PLAN REVIEW SHEET

FIRST SUBMITTAL

CATS acknowledges receipt of the site plan and submits the following to the petitioner:

SP101

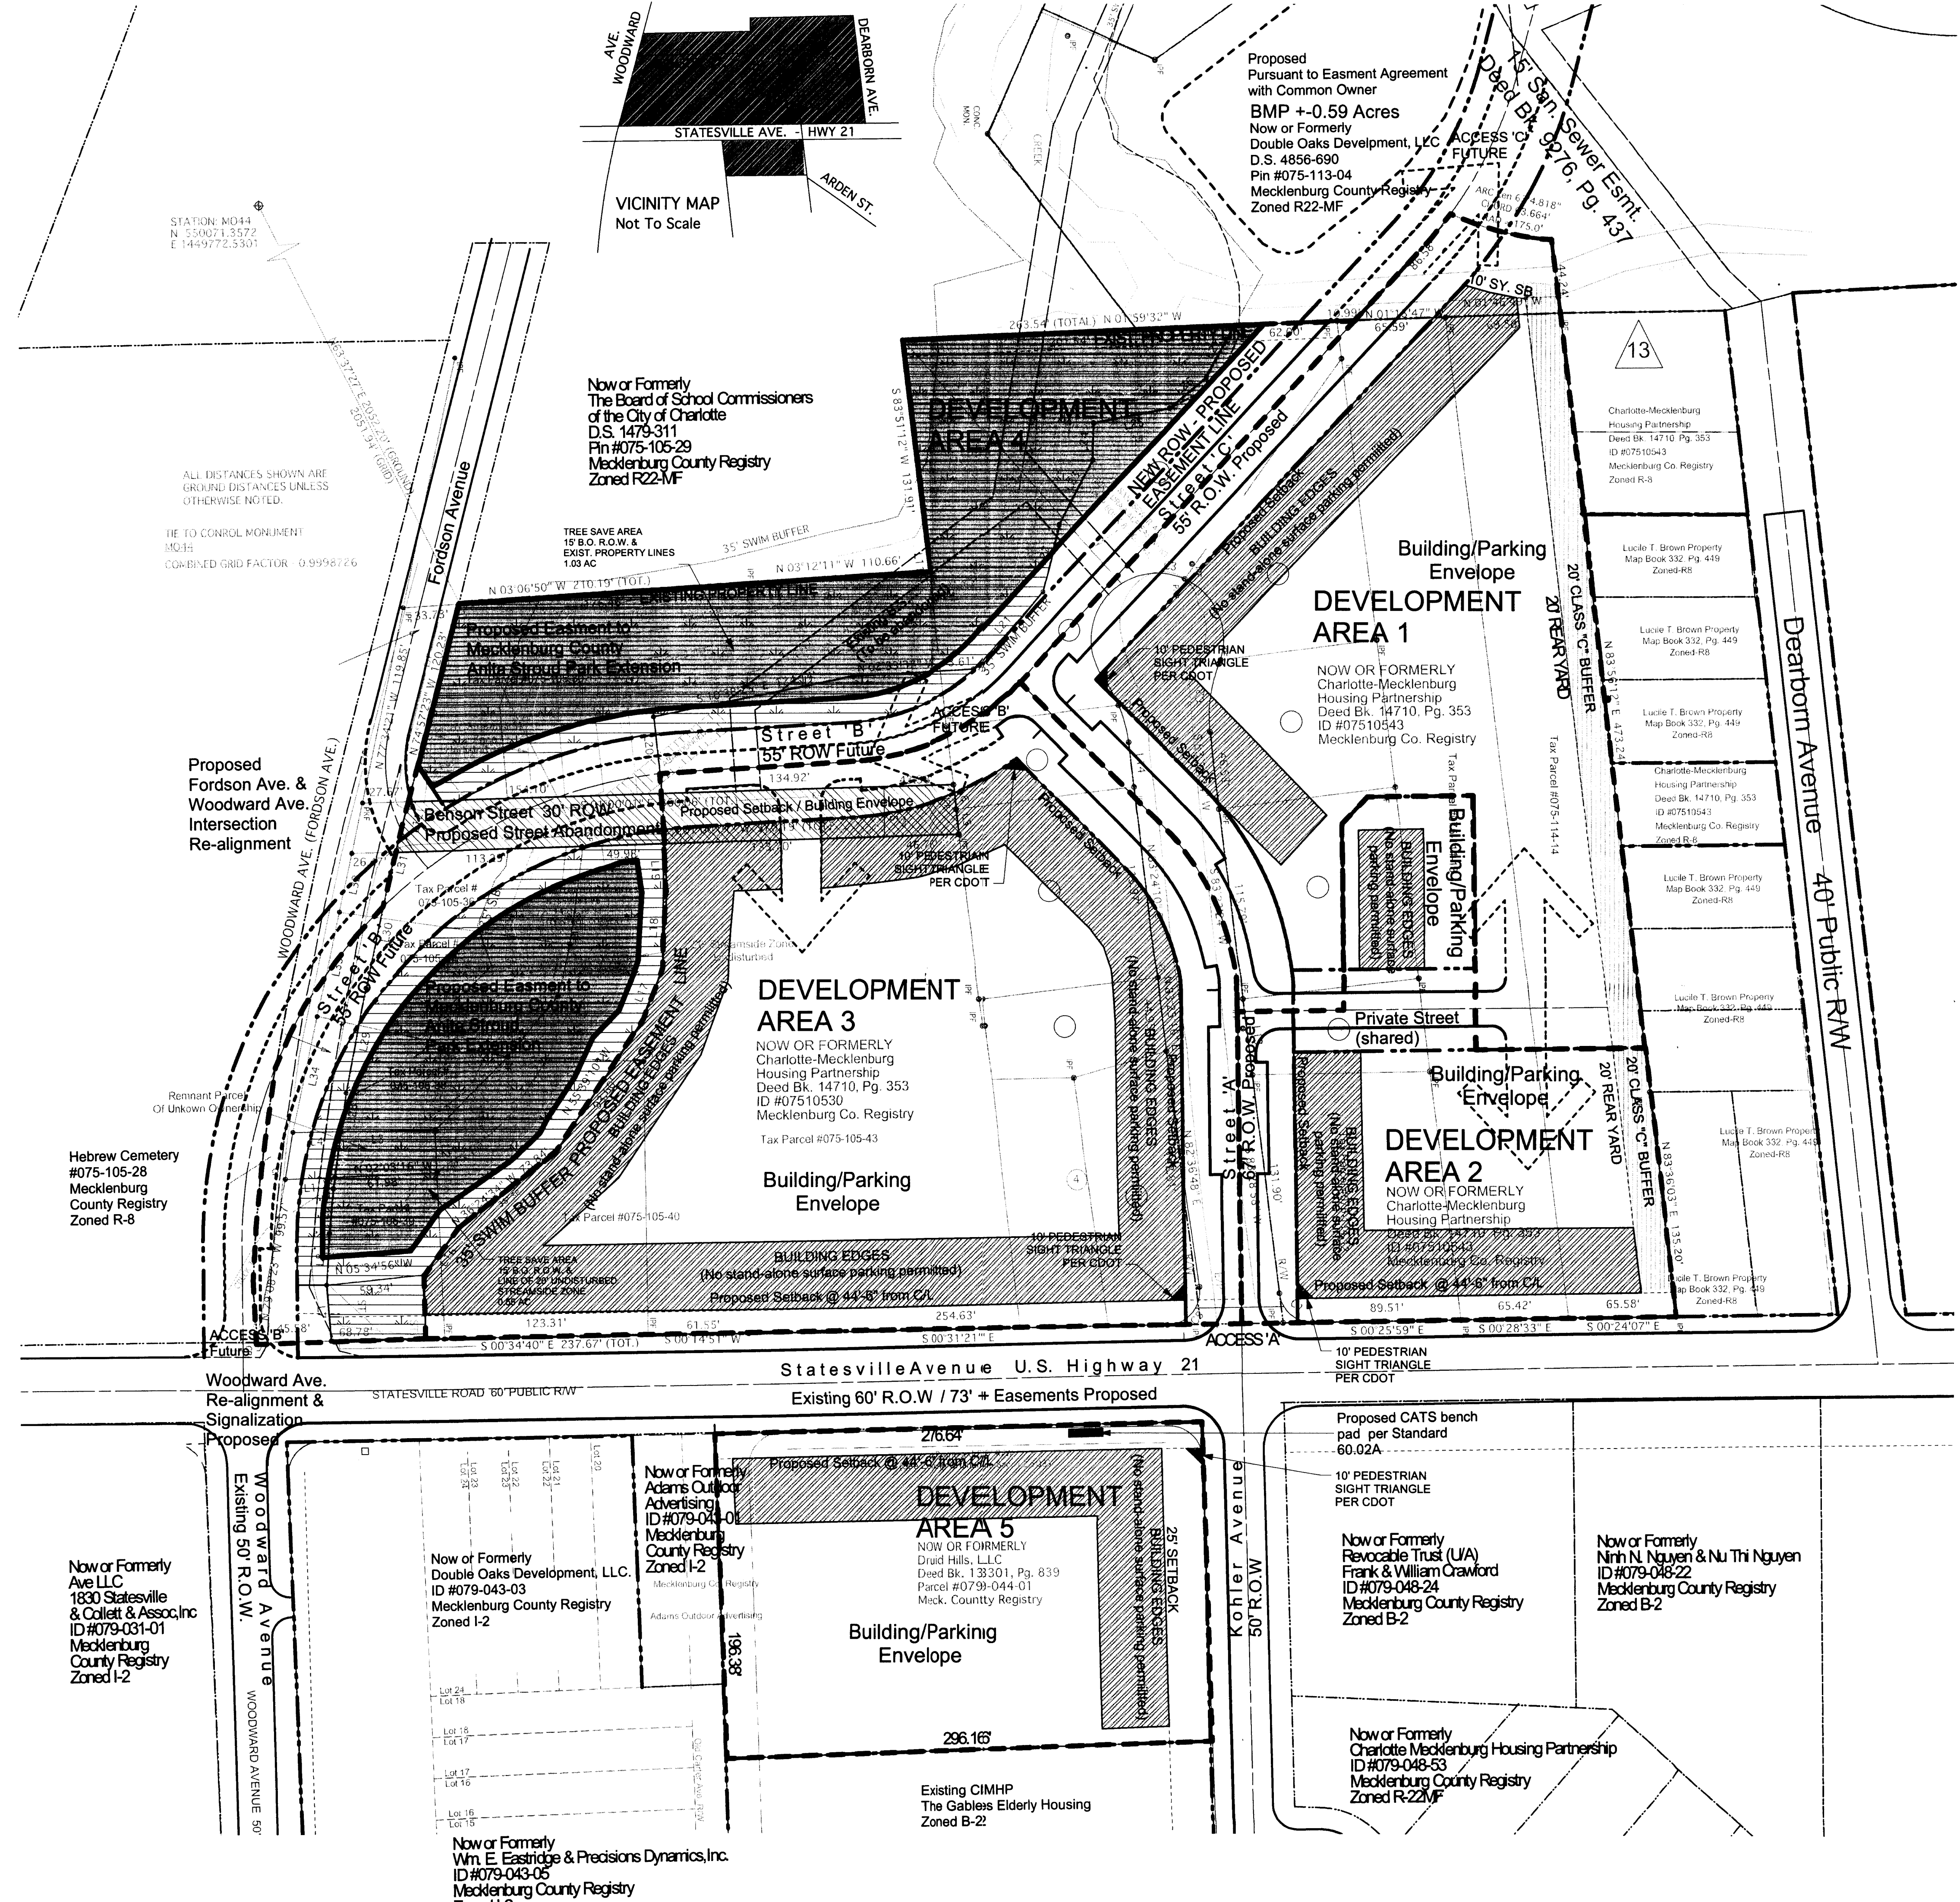
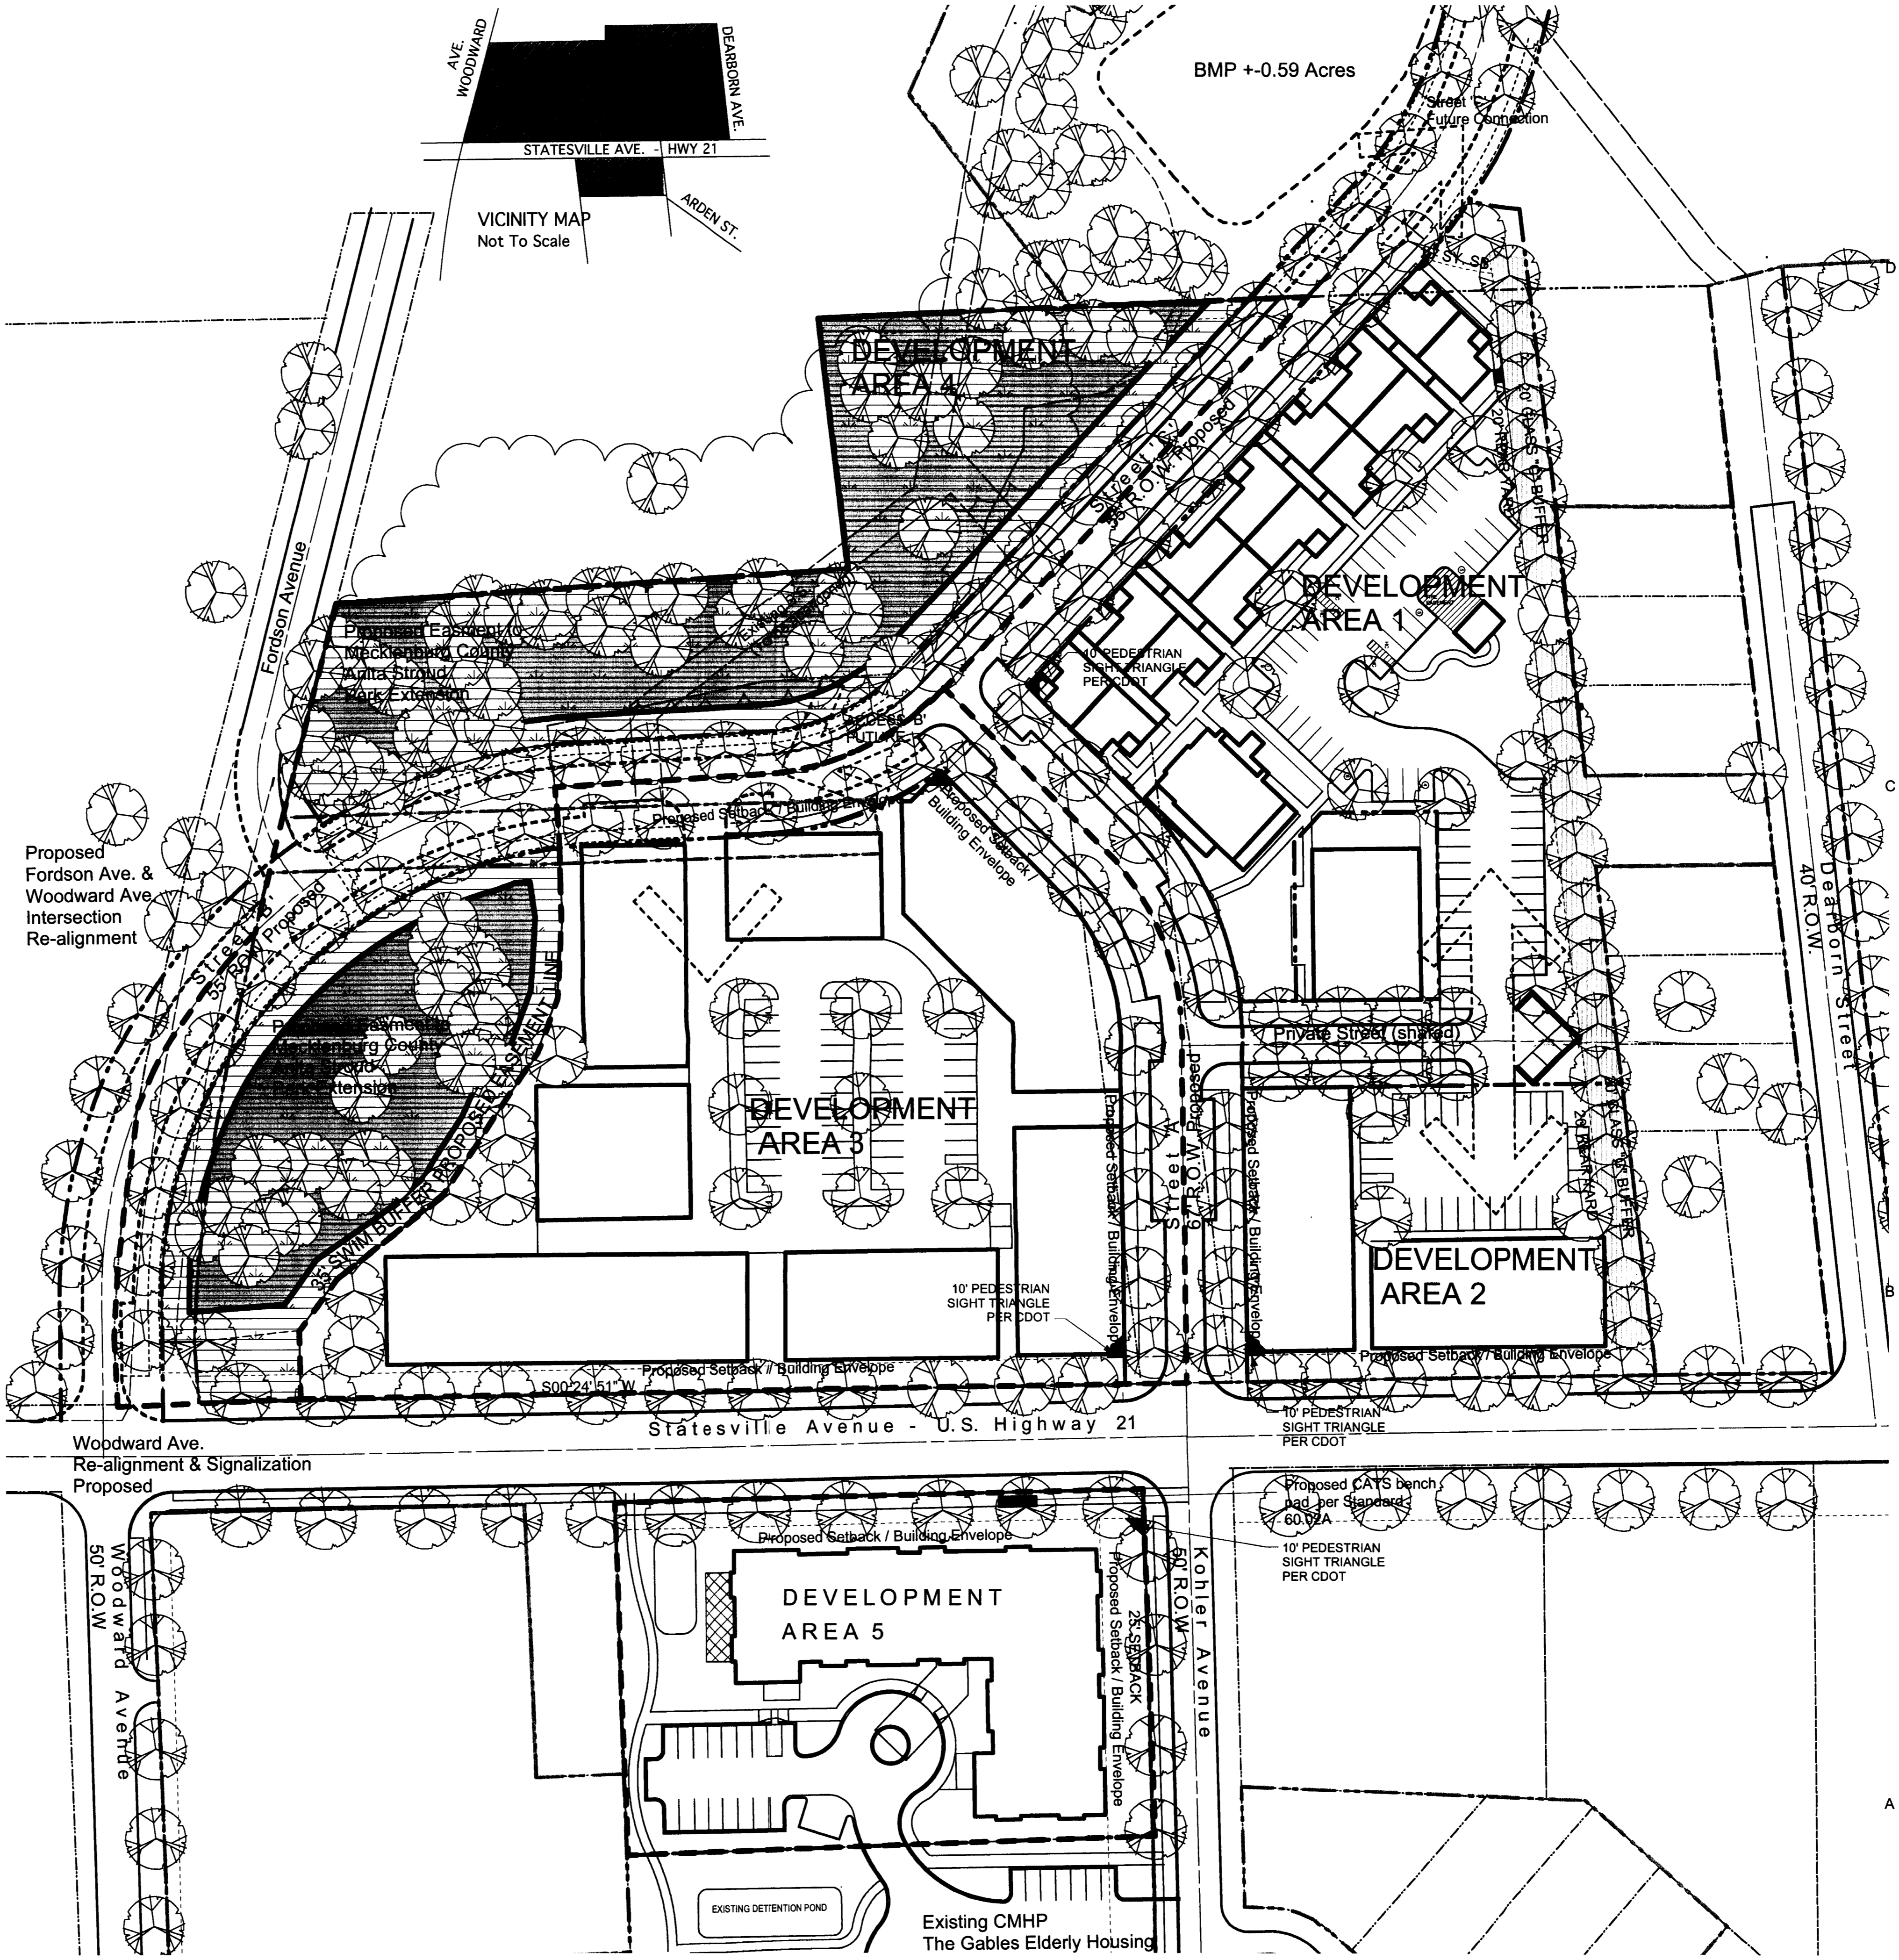
- 1) The petitioner's site is currently served on Statesville Avenue by Route 13 Nevin Road.
2) CATS requests the petitioner to preserve the existing sidewalk, waiting pad, bus shelter pad, bus shelter and bus stop currently located on Statesville Avenue (Transit Stop ID #30460).
3) CATS additionally requests the petitioner to construct a bench pad in Development Area 5 on Statesville Avenue, to be located approximately 60' South of the intersection of Statesville Avenue and Kohler Avenue, constructed to CATS Development Standards 60.02 A (see attached).

Please designate such in the site plan and/or accompanying notes. Please contact Leonard Ganther (CATS Operations) @ 704.432.1283 prior to demolition or construction, to coordinate any temporary relocation of the existing bus stop and bus shelter and to coordinate the final location of the new bench pad.
